Subject: Re: EP/16/21/PL

Drawing Number: 1241.01.h

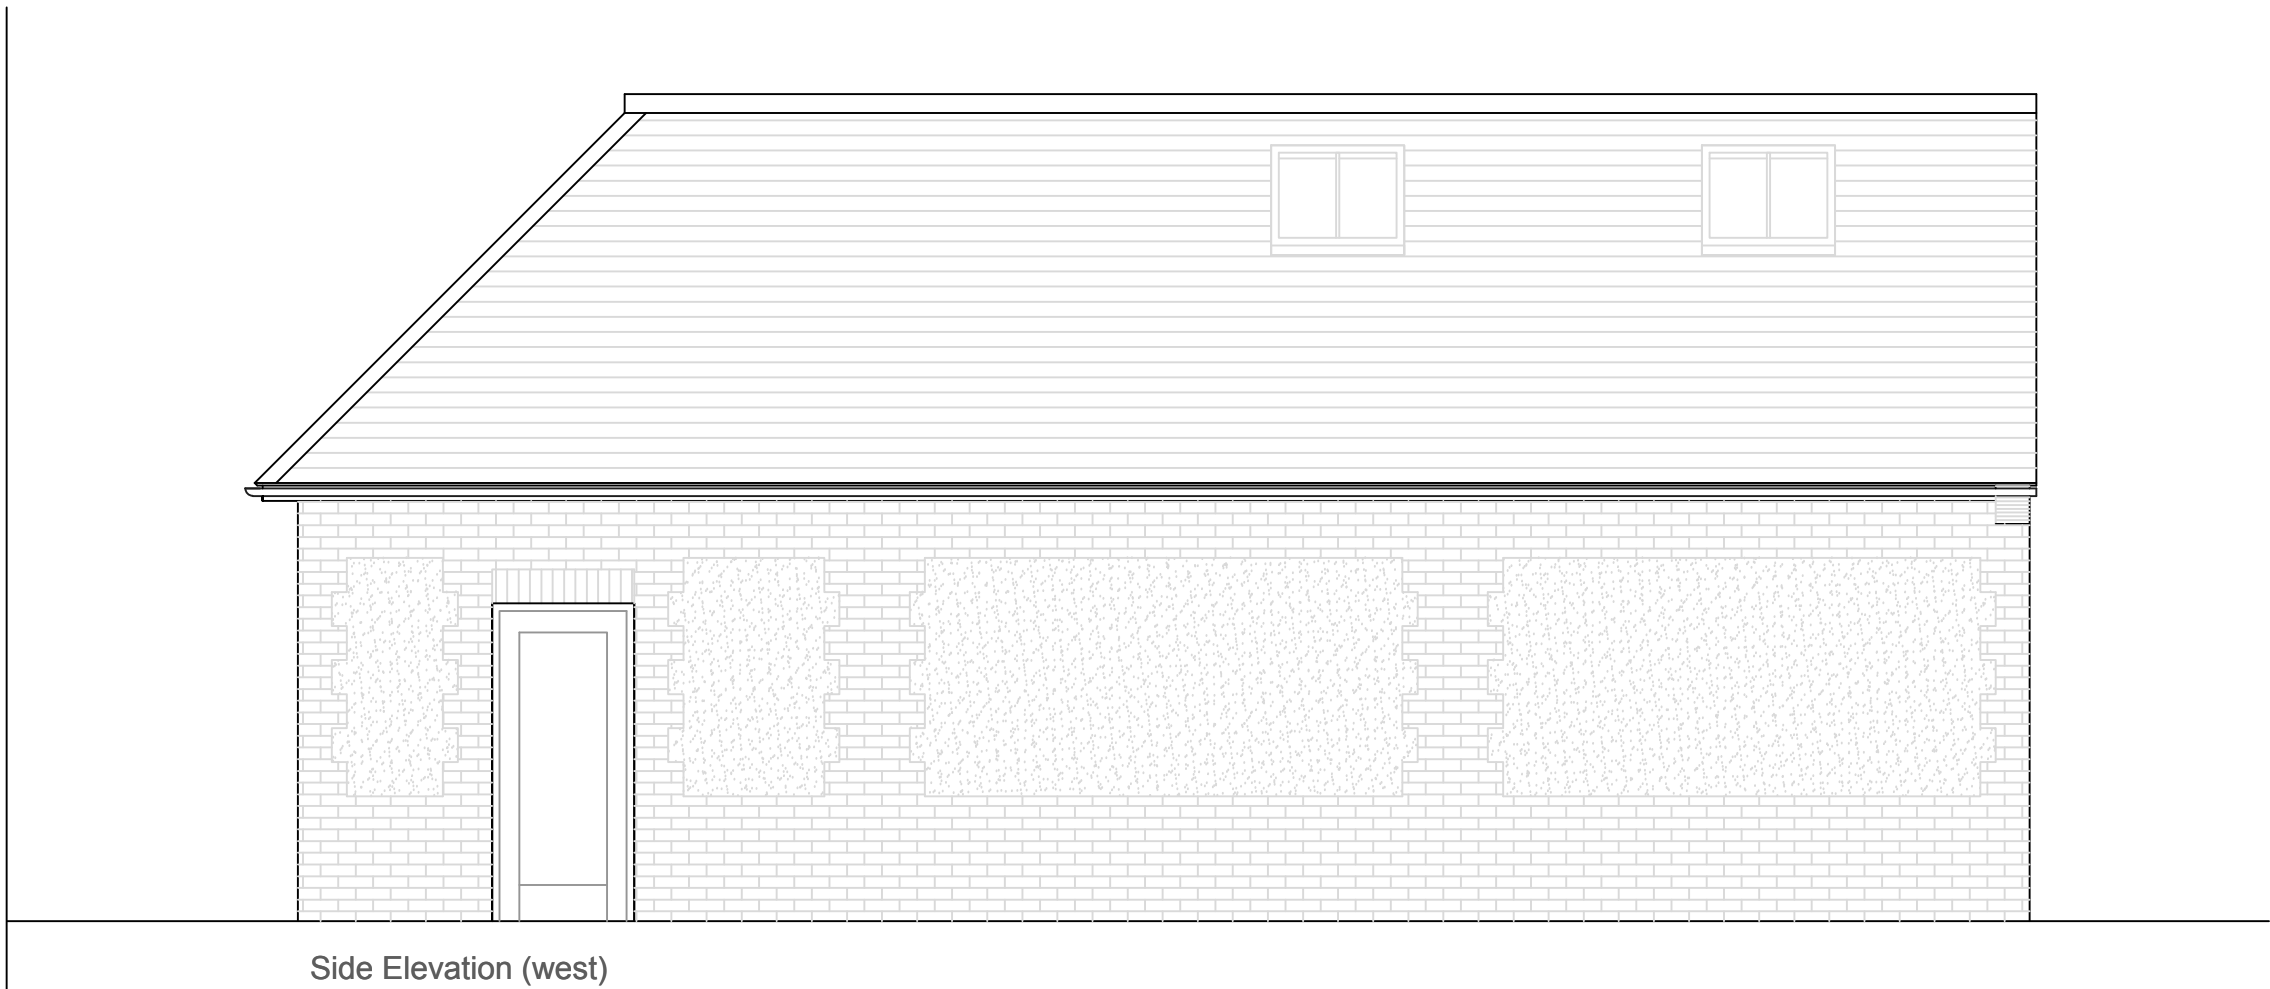
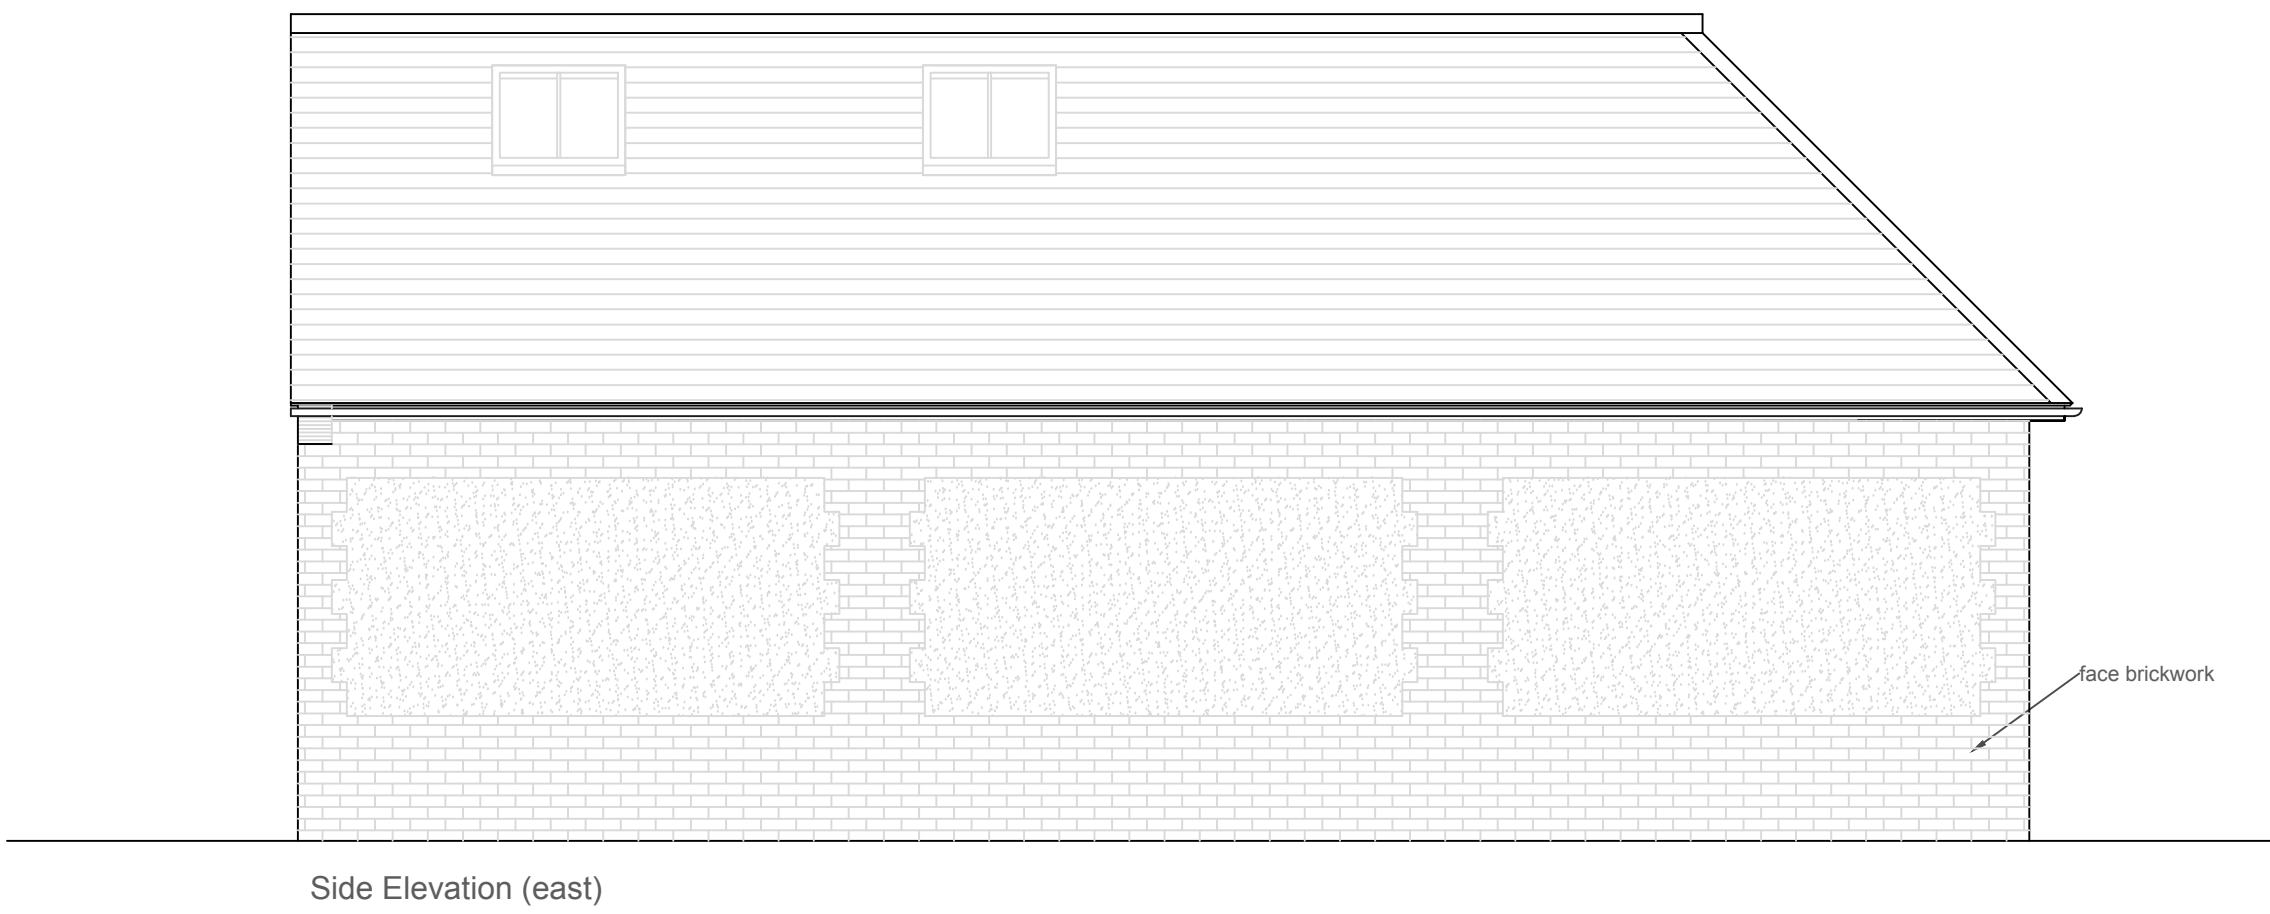
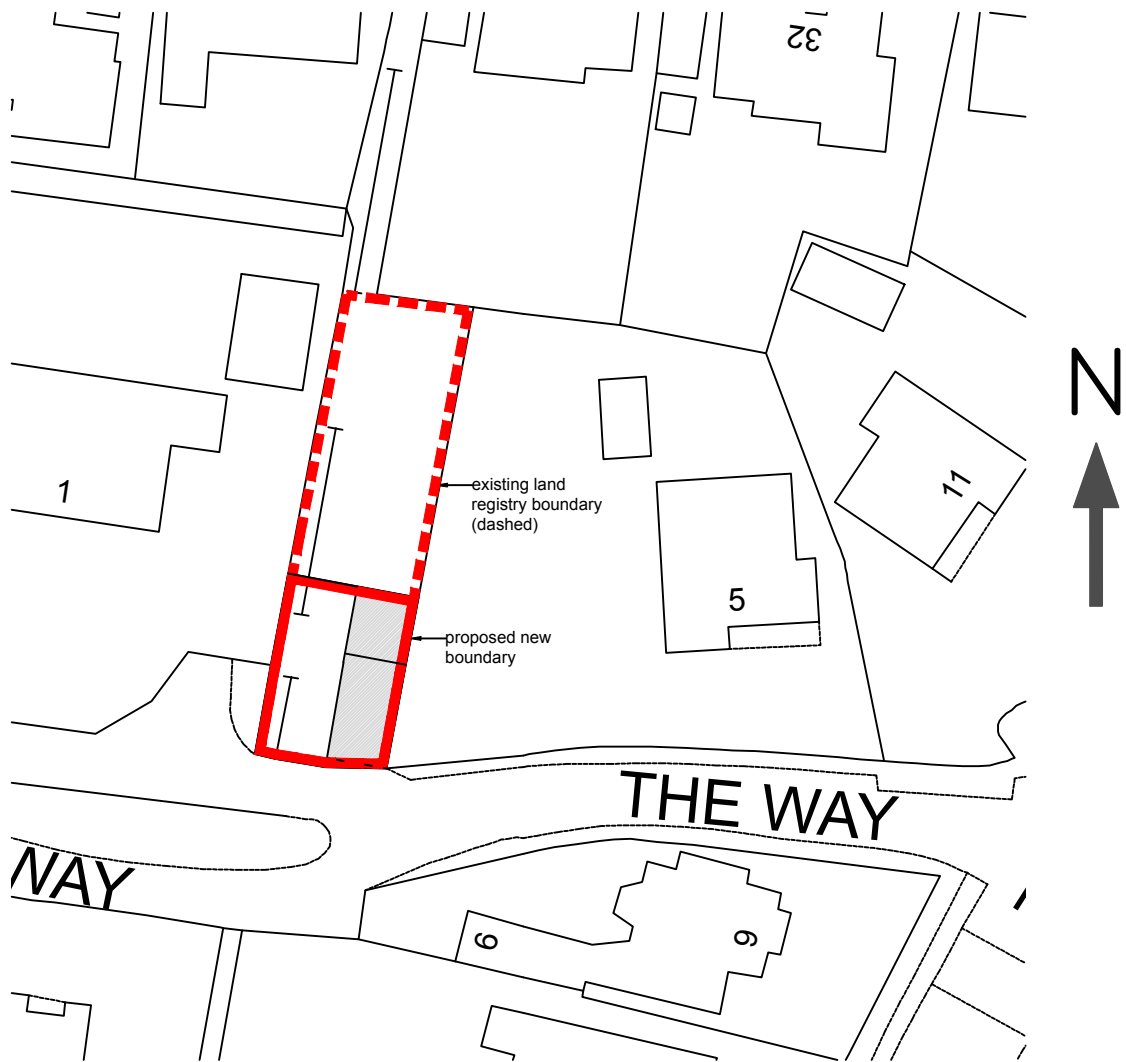
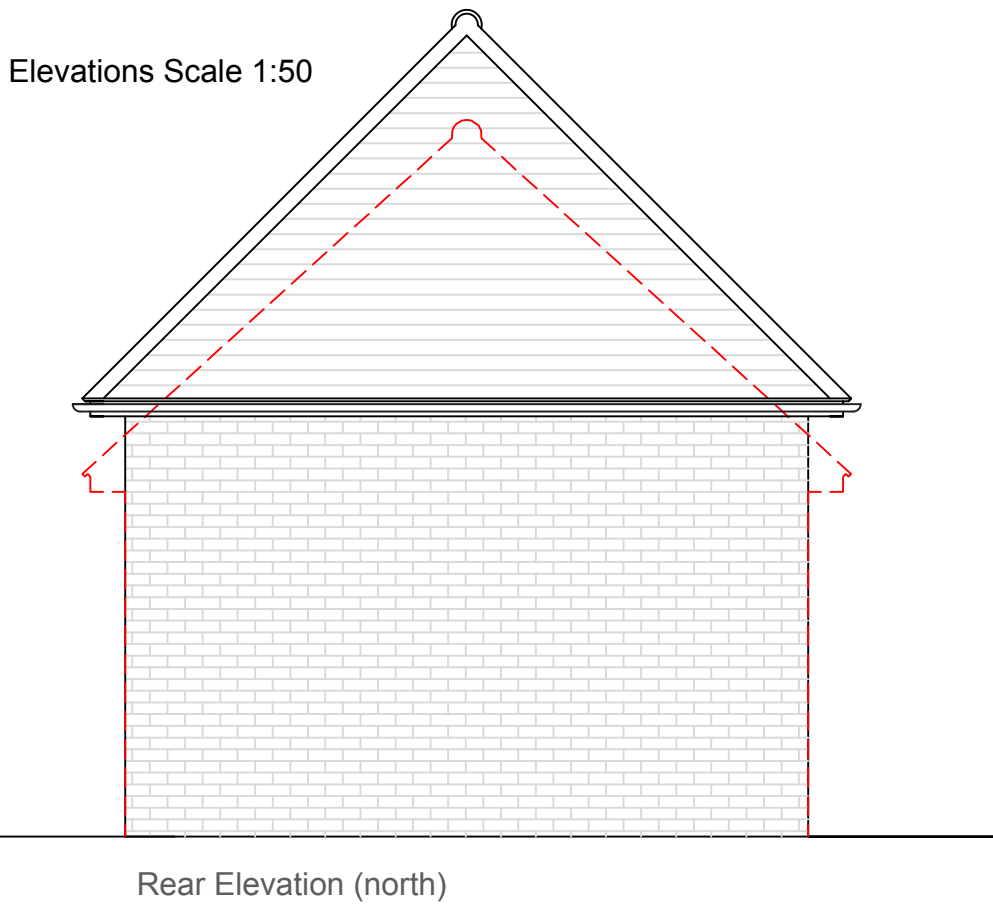
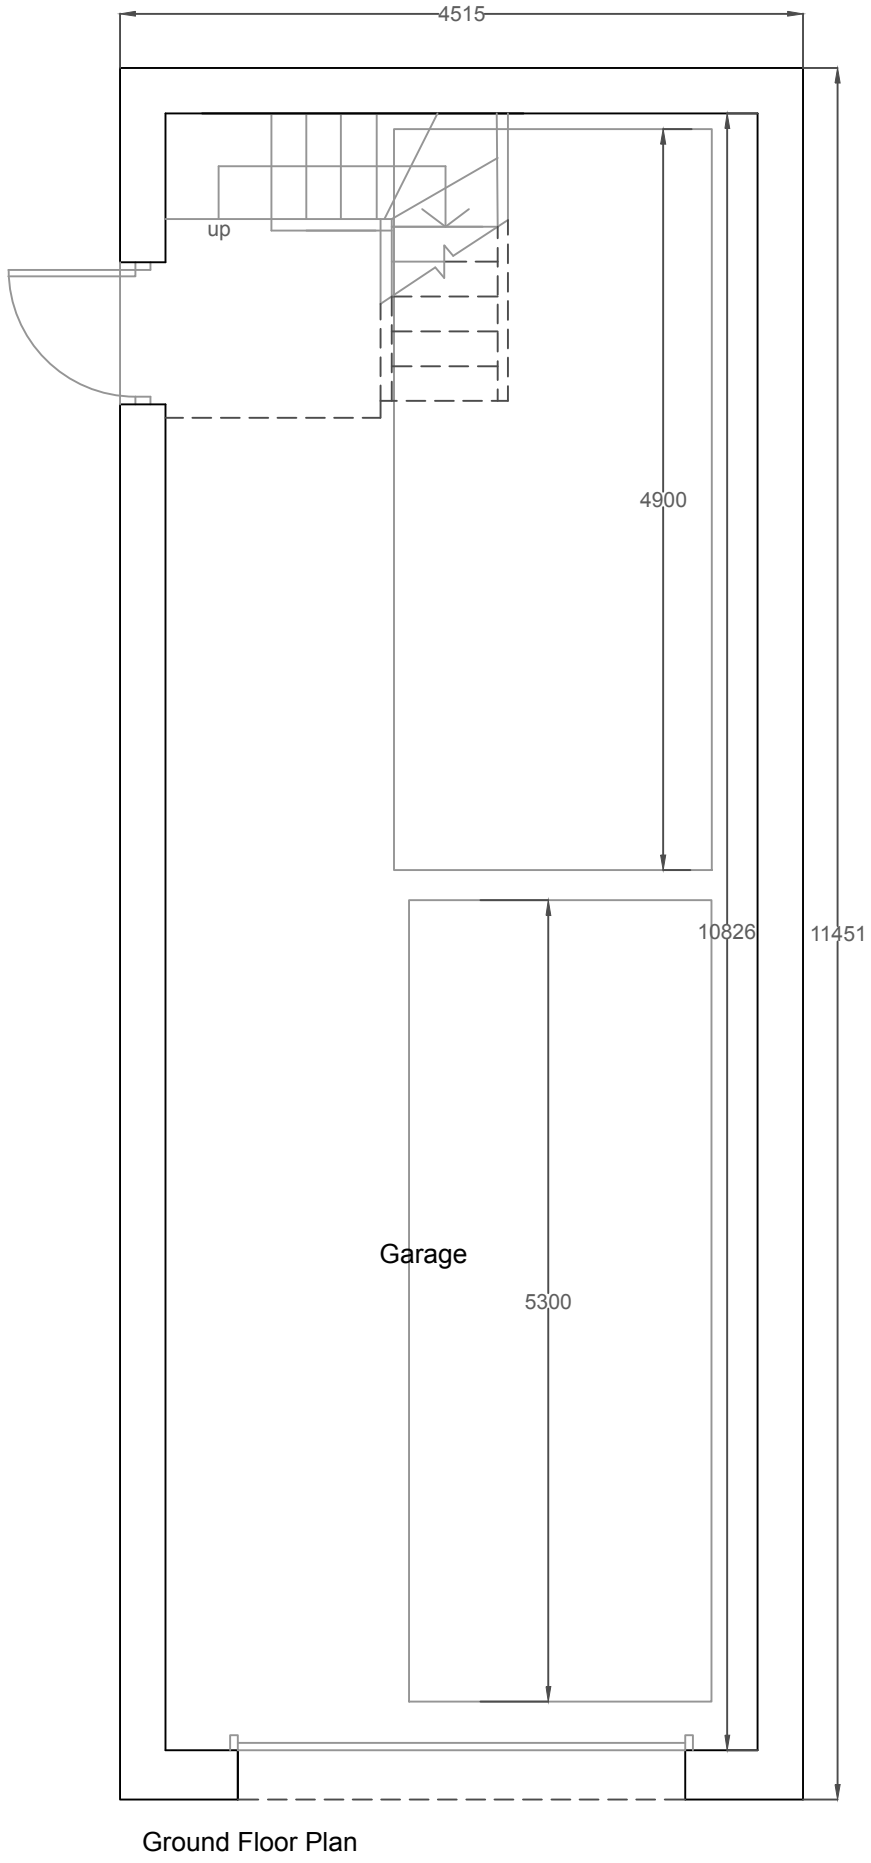
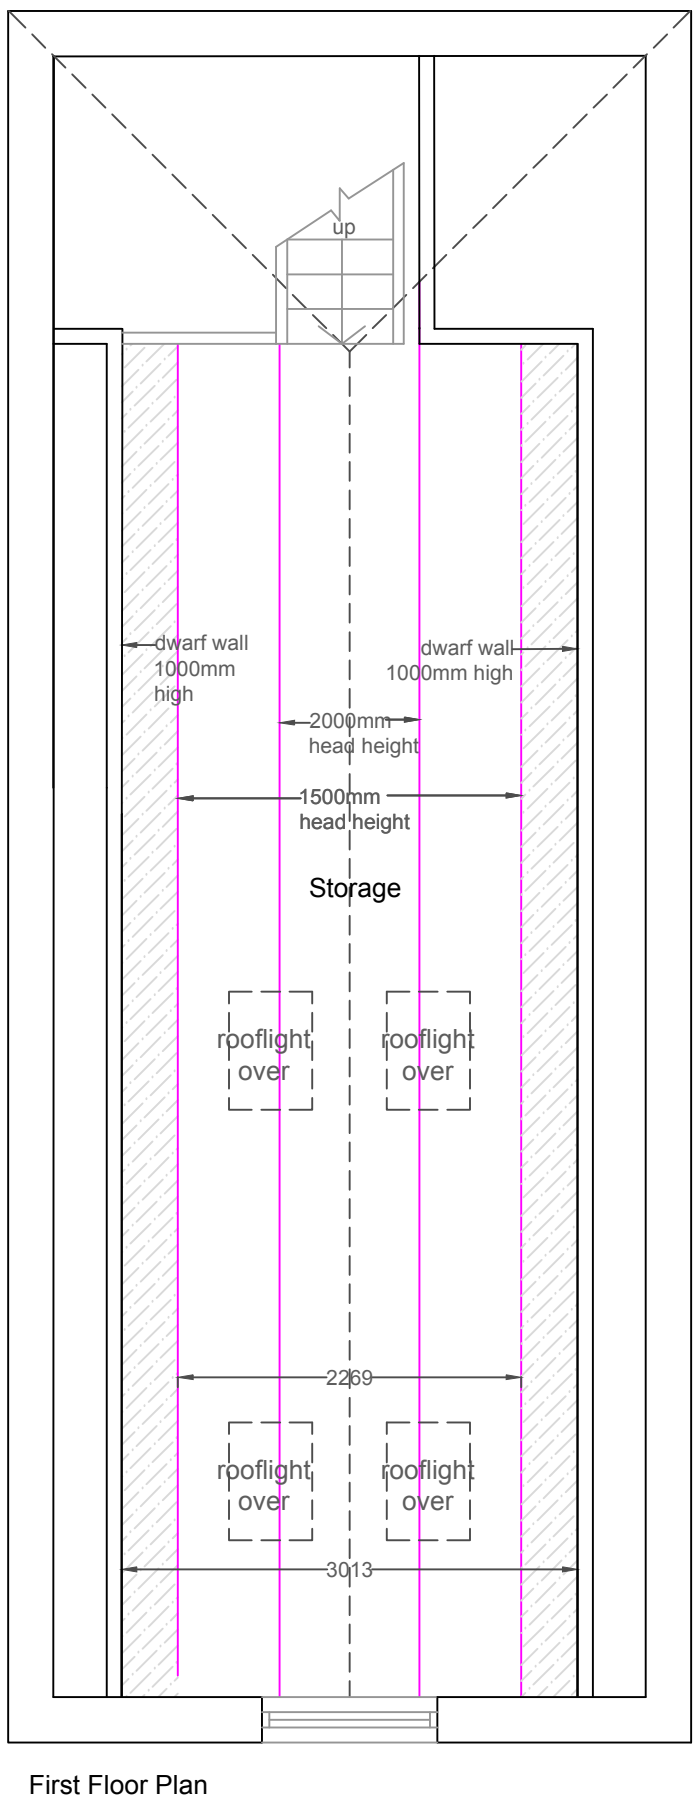
There has been a condition added to this application to show the three windows on the side (east) elevation of the garage will be permanently obscurely glazed and fixed shut up to a height of 1.7m from the finished floor level in order to protect the private amenity to the neighbours at the east. Please can you provide a plan to show this with a cross section from the ground to 1.7m to show the windows will be obscurely glazed and fixed shut up to a height of 1.7m.

There has also been concerns of why a dormer would be necessary for a garage if it is to be used as storage. As a result, it would be necessary to remove the dormer to the garage for this proposal. Please provide amended plans to show the dormer has been removed.

The three windows on west elevation should also be removed from the proposal as the garage will be used for storage there is no necessary need for windows, this will also create amenity issues.

I have removed the dormer and reduced the number of roof lights. I have also reduced the size of the roof lights and positioned them so the cill of the roof lights are 1.7m from finished floor level so there is no overlooking. I have included a section to demonstrate the position of the roof lights.

I have reverted to a hipped roof at the rear of the building which is as per the pre-application advice scheme. I have done this in order to accommodate the staircase and still provide space for the two cars in the garage.
